**CITY OF ALBUQUERQUE
PLANNING DEPARTMENT
December 3, 2014
DRB Comments**

PROJECT # 1010286

APPLICATION # 14-70388

RE: Fairview Park Cemetery

SHEET 3 OF 4 BOUNDARY

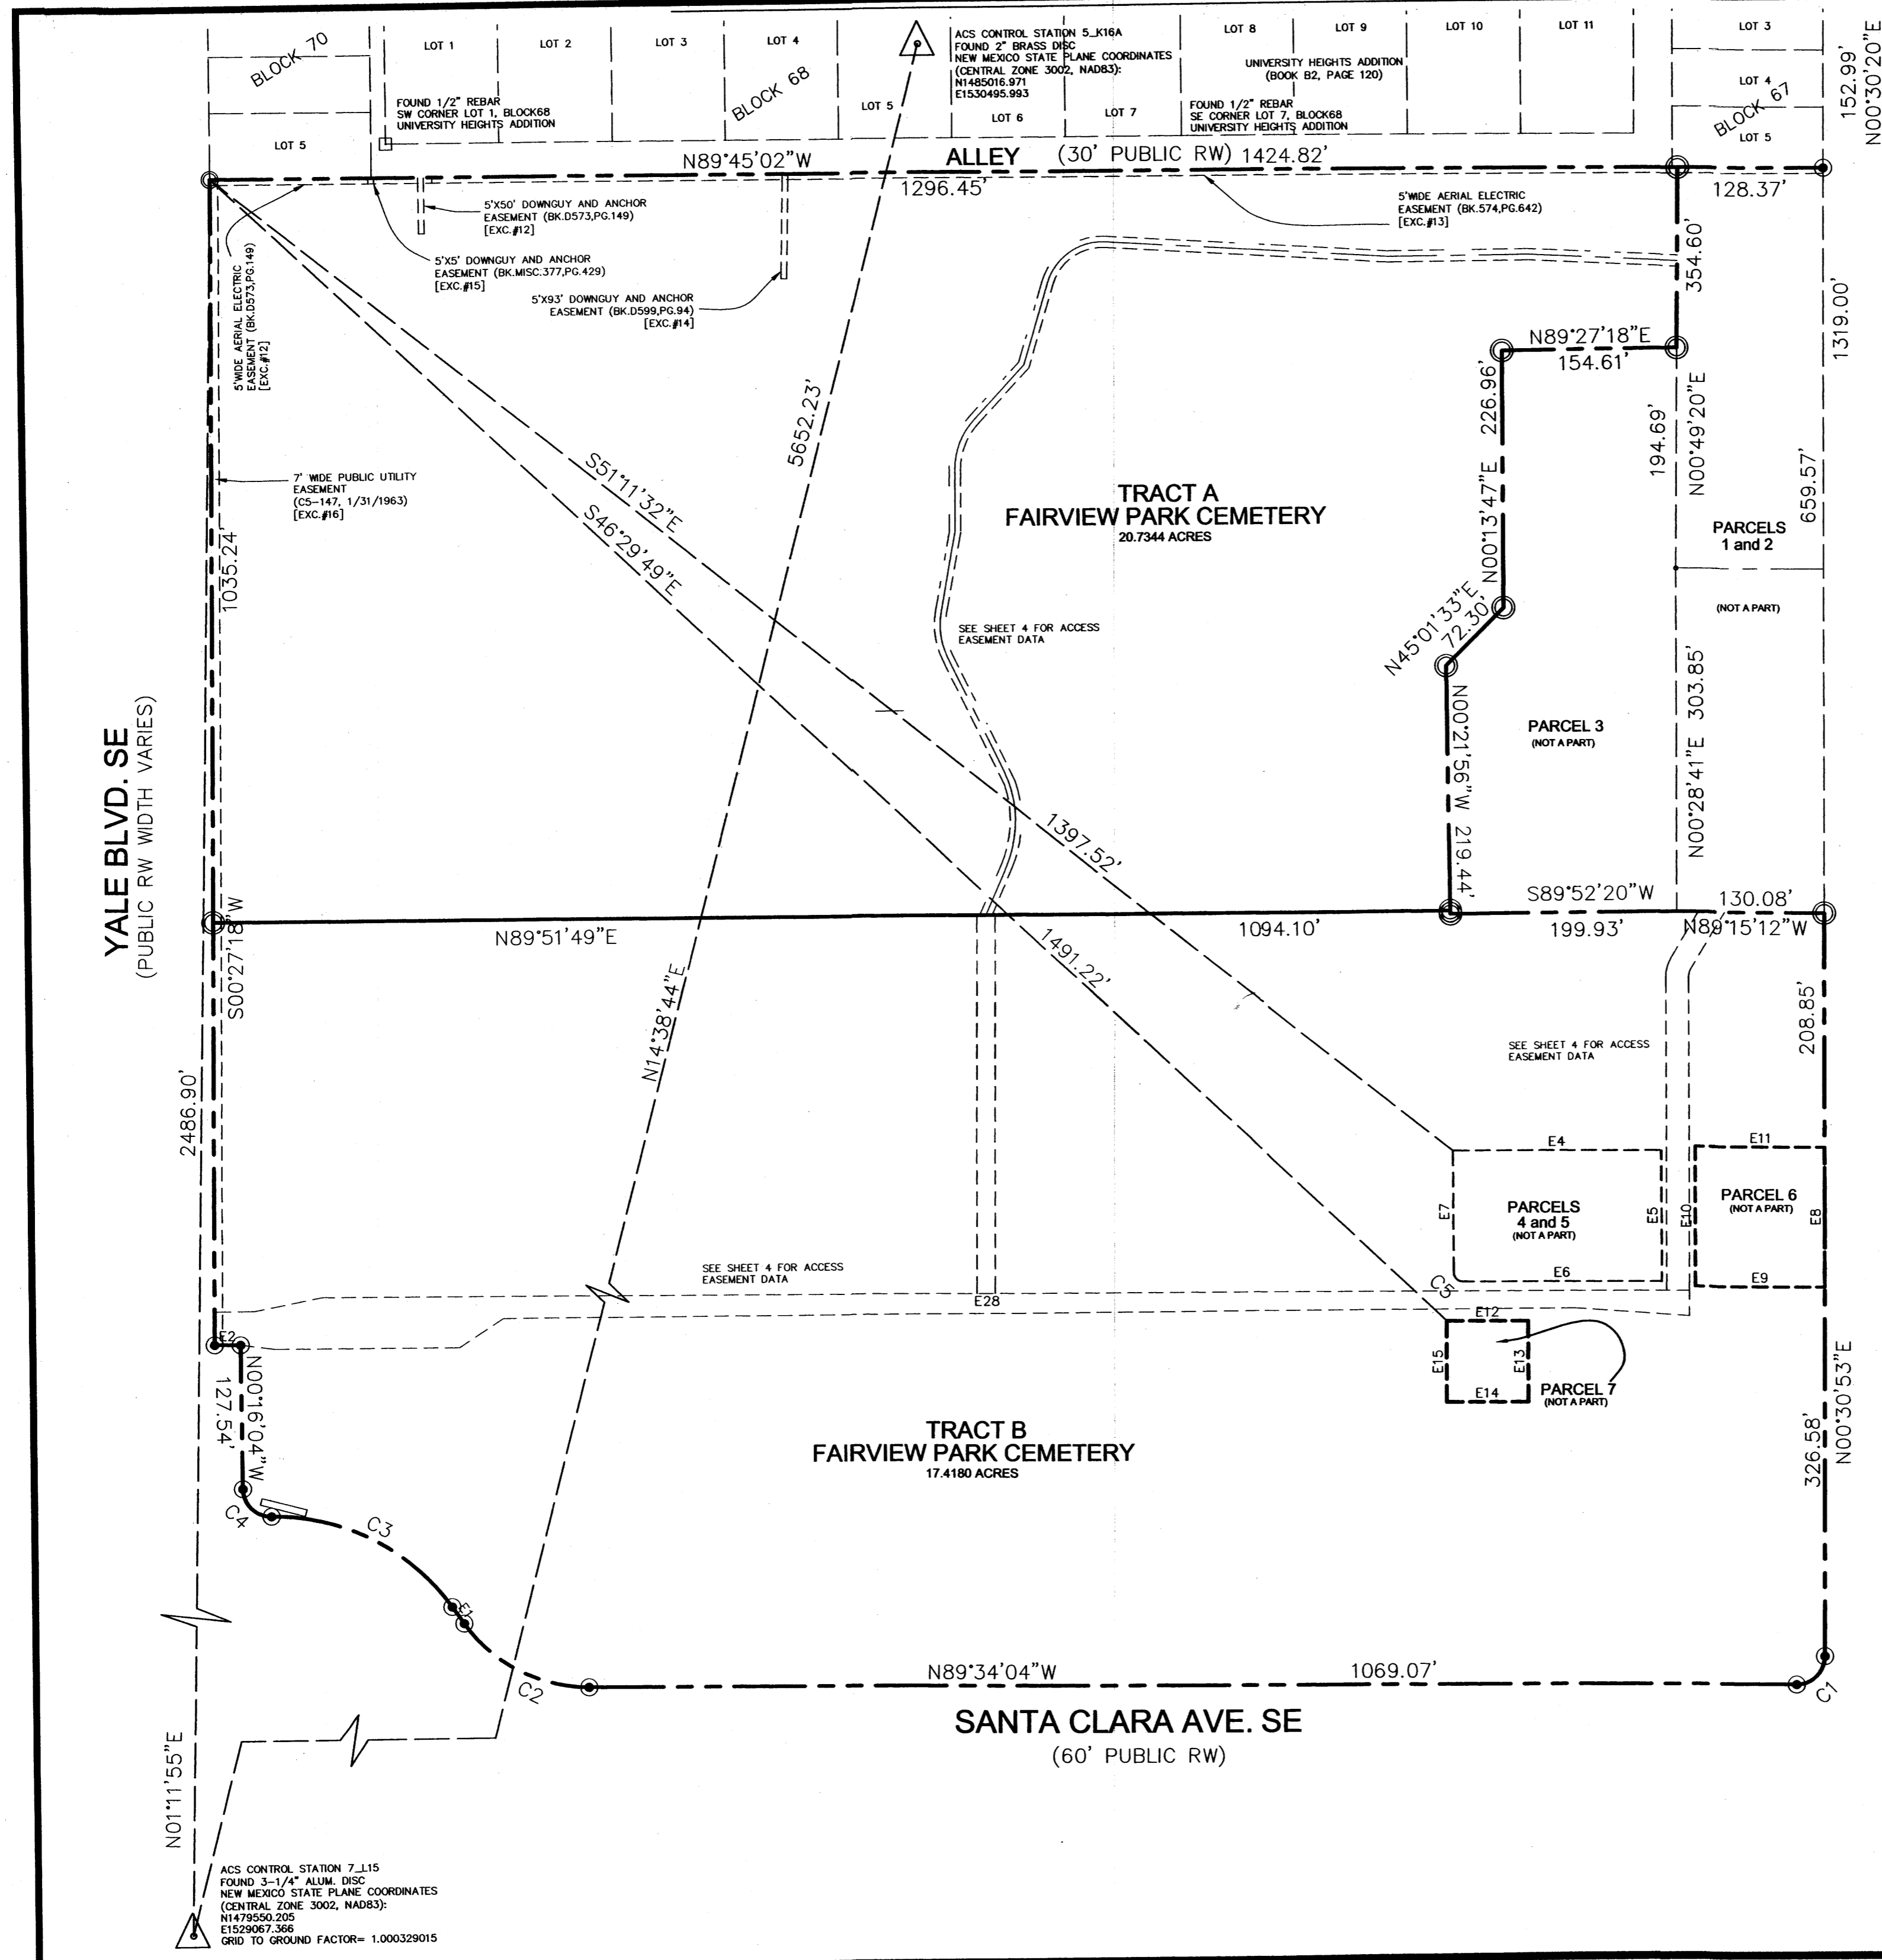
Parcels 4-7 need to be clarified. They do not appear to be created before 1973 and therefore may not be legally subdivided. Access easements are needed with this platting action; maintenance and beneficiaries need to be noted on the plat. All parcels need to have access to public ROW and therefore need to be included as beneficiaries.
